Your Ref: OWPC14143
Our Ref: AB/60/17/PL 26-04-2017
Please ask for:
Mrs A Gardner

1 No. dwelling with carport & associated off street parking (resubmission following AB/130/16/PL).

Land rear of 74 & 76 Canada Road Arundel

Thank you for your internet representation made on 4th June 2017 which has been recorded as '**an objection**' with the comments as follows:

Drawing Title
Proposed No 3 bed Detached
bungalow rgs plus associated
off road parking.
Plans

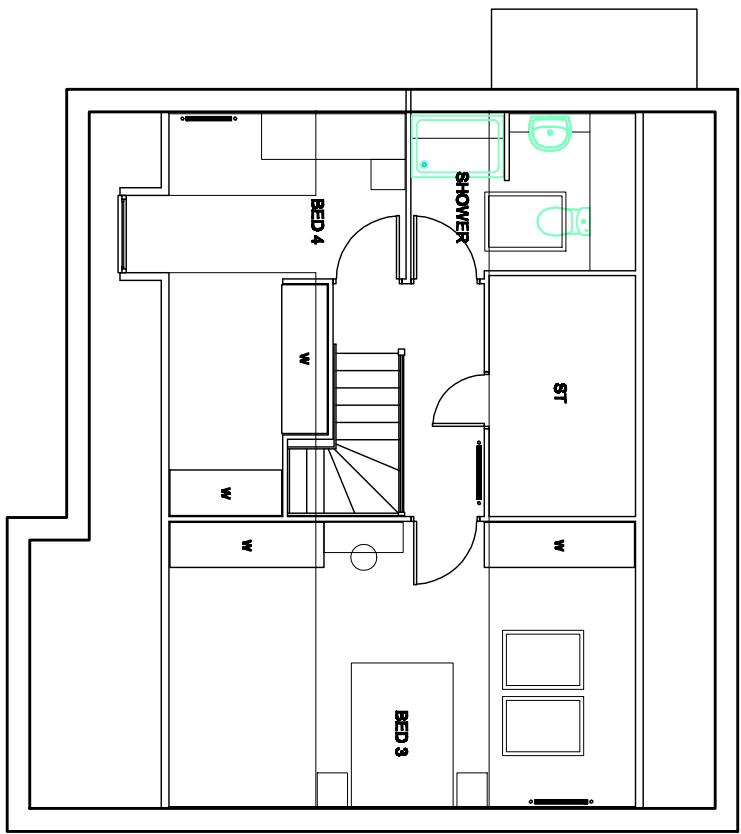
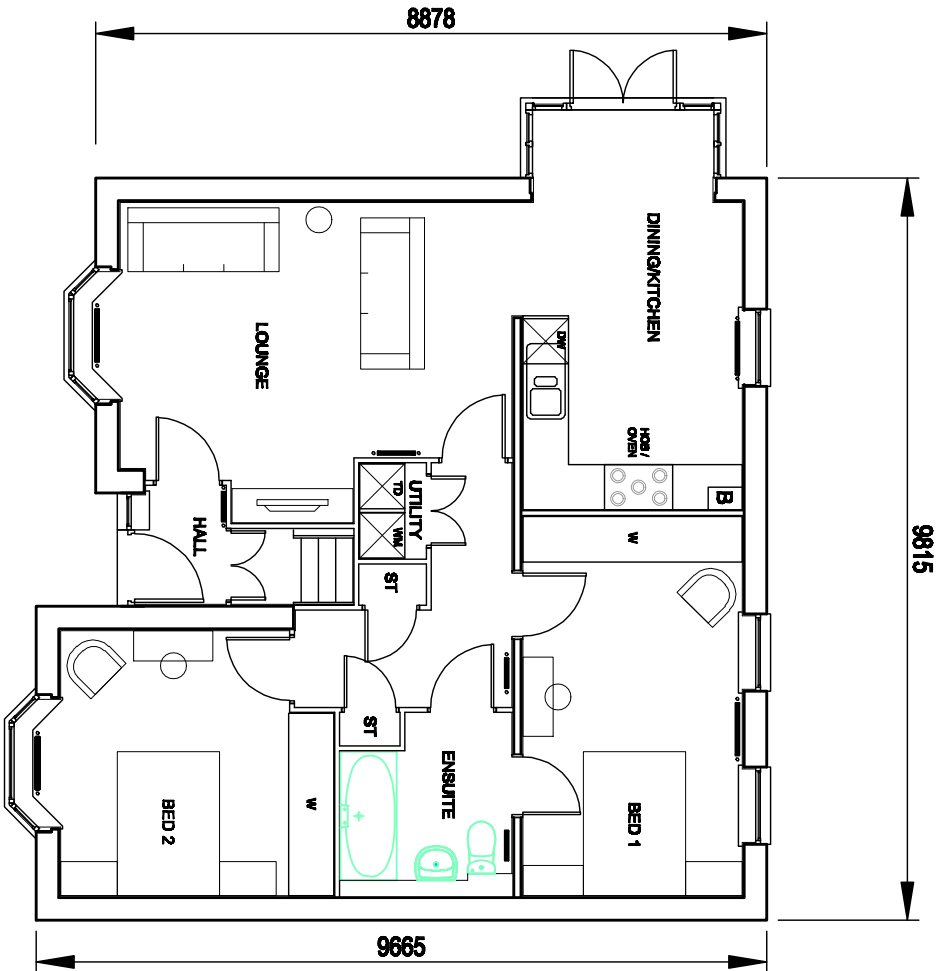
Privacy - The proposed development from the plans is for a four bedroom bungalow, set over two storeys, and not 3 bedrooms. The building of this two storey property will seriously impact on the privacy of our family. The rear of the proposed building will be just 6 metres from our boundary. We objected previously when it was 10 metres. This has been further reduced. Although a bungalow it will be over two storeys, the height of the purposed building will completely over look our garden and into the rear of our home. A fundamental human right is the right to a private life. The erection of this dwelling will impede this right. Parking - The area is blighted by parking problems. From the plans a new crossover the width of at least four garages has been implemented thus losing a significant amount of existing on street parking. Currently the on street parking is available for all residents. However the crossover point will be removing these spaces and reserving parking for those who are involved in this project. This will have a detrimental impact on a number of residents locally. I see that there are also two individual garages and drives for no. 76 and 74. These add to the loss of on street parking. The existing double garage at 76 is not currently used for parking. In the plans it is said there are no current parking provisions and this project will create 4 spaces. However any perceived gain is off set by the loss of on street parking spaces to allow access to the proposed development. This is simply monopolizing already limited parking.

Development Layout 1:200

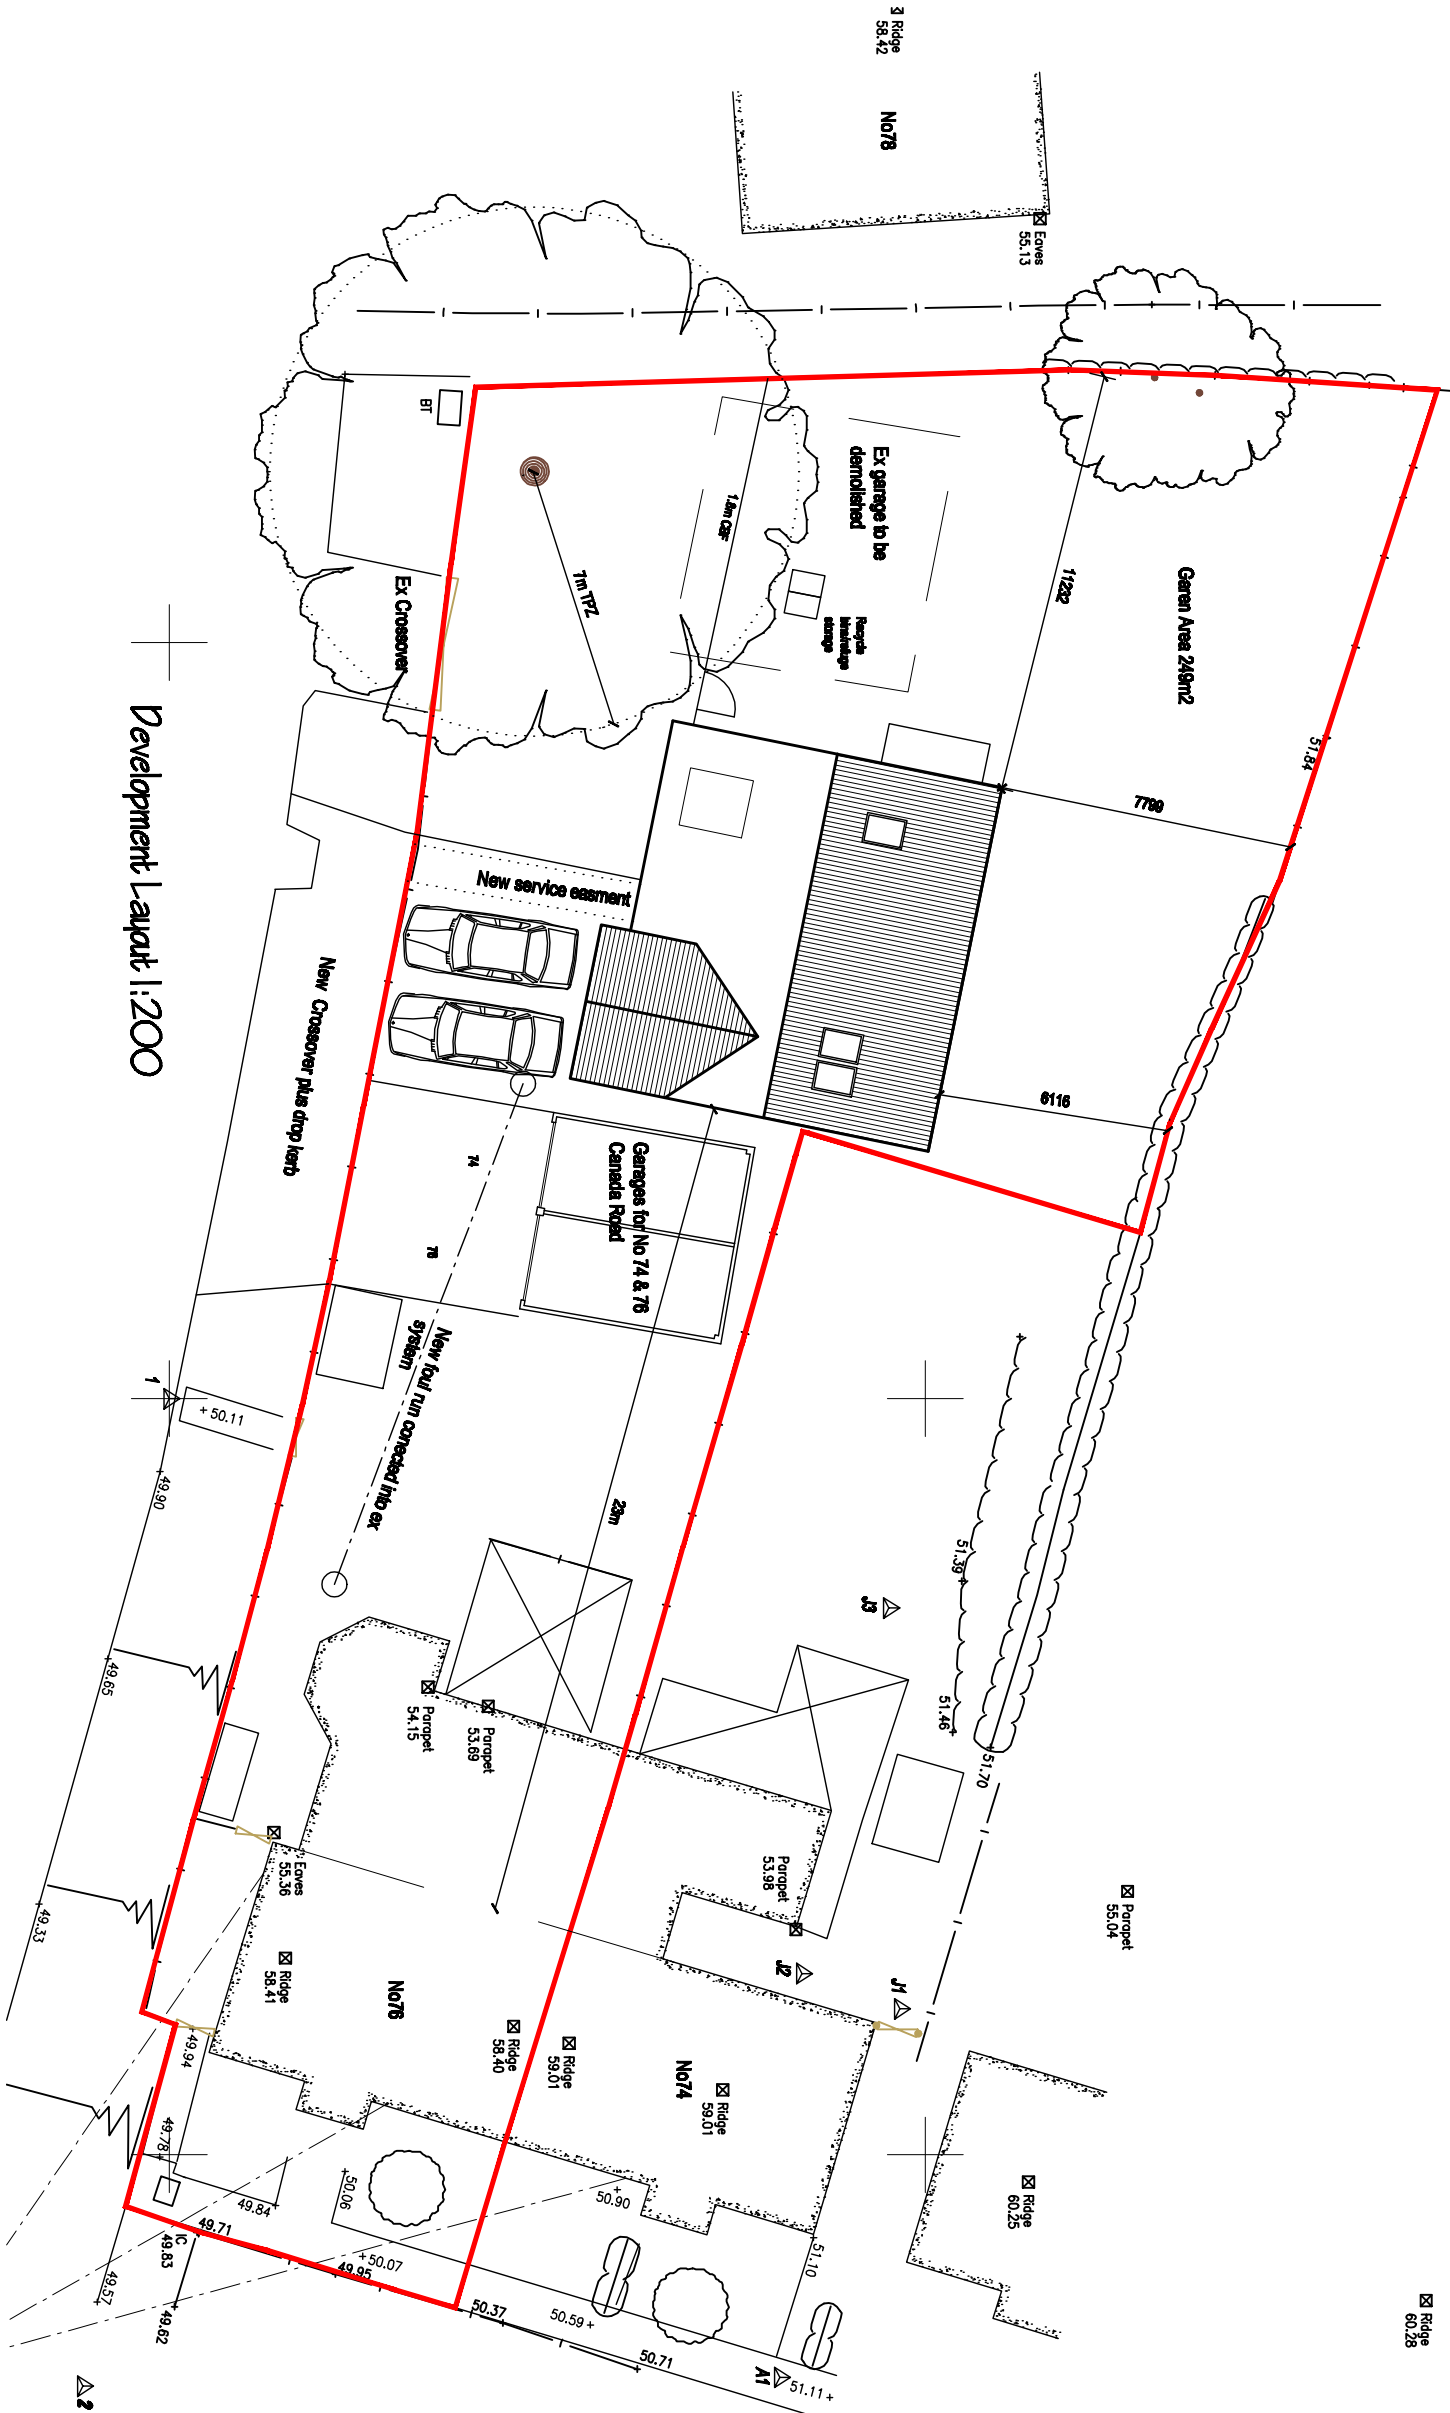
Flooding - Looking through the application there is a question- Is the proposed development within 20 meters of a watercourse (e.g. river, stream or beck) this was answered no. This is incorrect. There is a substantial watercourse by way of a piped culvert, which runs directly through the proposed development site. This provides land drainage for farmland north of our dwellings to prevent flooding of the A27. Said culvert has flooded several times since we have lived in our property. We have video footage (filmed Jan 2016) of the effects of this. The water passes through our garden downhill and running onto Canada road via the proposed development site. It is of great concern that building work of this nature will interfere and potentially damage the piped section of culvert running through the site, causing severe flooding issues. As riparian owners all residents with a culvert within their boundary (or adjacent) have a responsibility to maintain and protect the culvert. I would like to draw your attention to a section from the Environment Agencies Policy Regarding Culverts 'Technical Guidance on Culverting Proposals (6.0 -6.5 Development proposals/building over) where it states:

The overland flow route is currently through the proposed development site.
